Subject: A/127/21/DOC in respect of Condition 19 A/46/19/PL - Land North of Mayflower Way, Angmering

Environmental Health: Agree to discharge of planning Condition 19 (A/46/19/PL) .

Subject: RE: A/46/19/PL - Land North of Mayflower Way, Angmering (Condition 19)

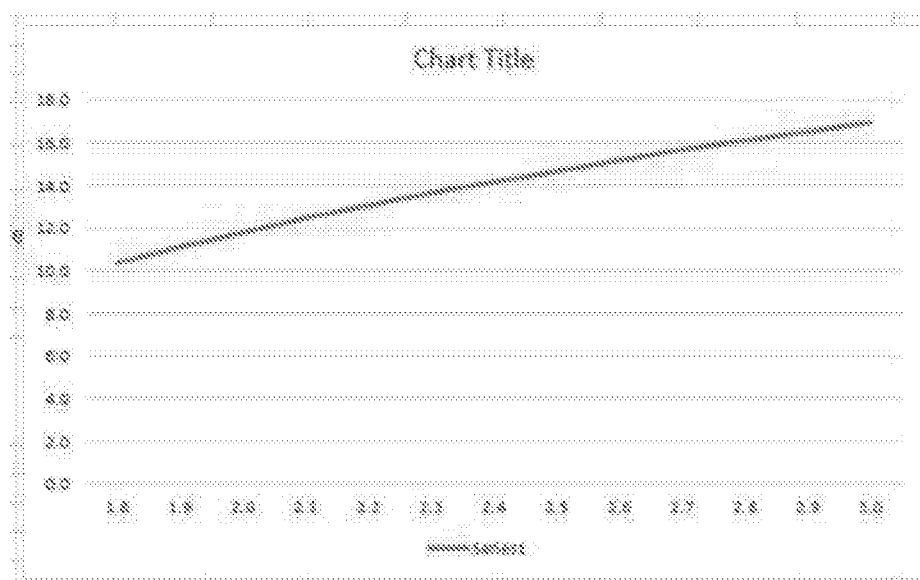
1. A new 3 metre Enviro acoustic fence, as detailed in this application, will be provided in that area depicted as a green line on the photograph 24th May 2021, (below).

Thank you for your update, as below. In the case that you have agreed to provide a 3 metre Enviro/similar acoustic fence for that area depicted as a green line on your photograph 24th May 2021, this will allow discharge of planning Condition 19 (A/46/19/PL) in this case. I would be obliged if you would forward manufacturer's details of the fence to me please.

I trust that a suitable 3 metre Enviro/similar acoustic fence can be provided, which will be for that area depicted as a green line on the accompanying photograph. I can confirm that should this be acceptable to you/the applicant, then this would be considered sufficient to allow discharge of planning Condition 19.

I also accept that on the basis of your findings, it will not be necessary for a new acoustic barrier to be provided in that area south of the kennels, shown in blue.

12K ENVIROFENCE FENCE – 3m HIGH

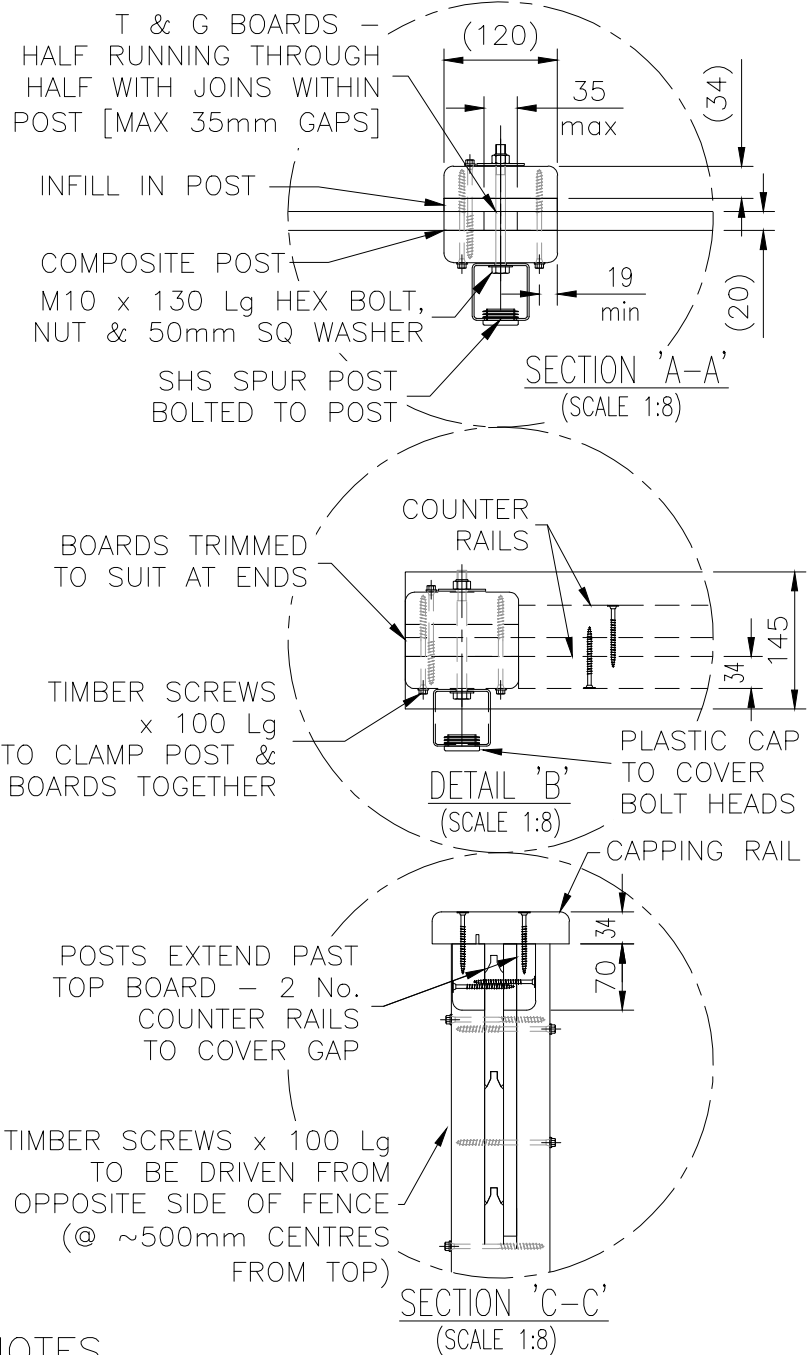
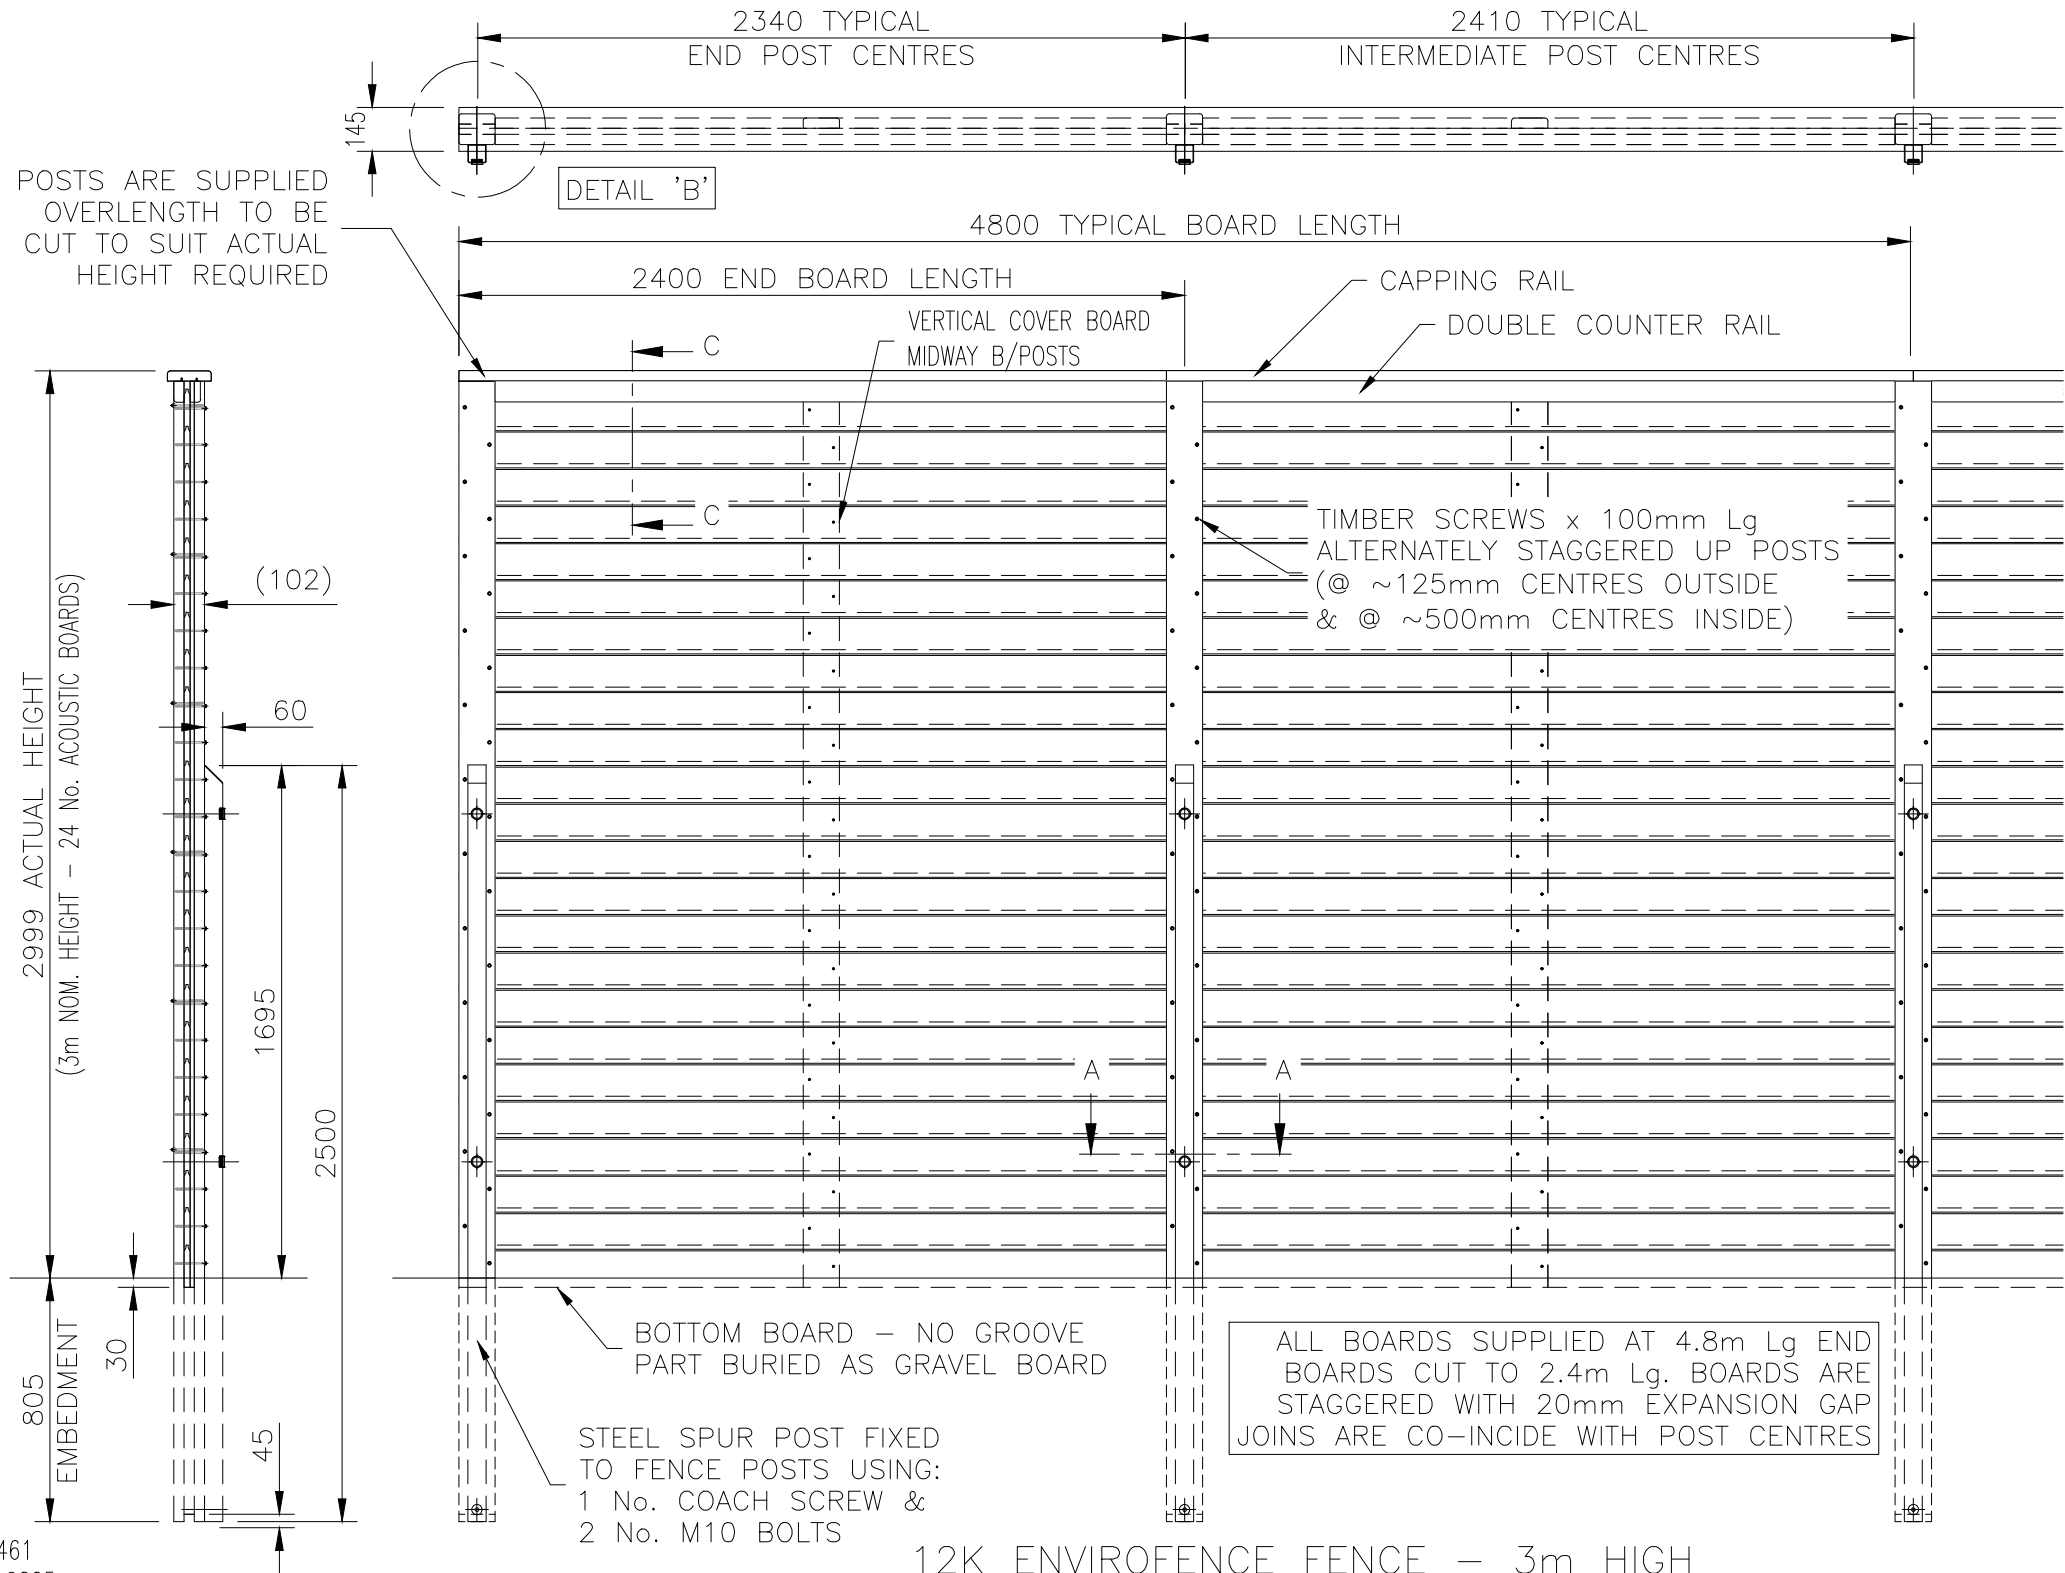
Although, it would be unlikely that we would require an existing 2.5 metre acoustic barrier to be upgraded to 3 metres, given the nominal improvement in the sound environment, we are considering the situation where there is no existing receptor and no existing acoustic barrier. I would therefore contend that it is preferable to provide an optimal 3 metre acoustic fence that provides 17dB of noise reduction, as being more appropriate for this situation and more likely to protect the local amenity.
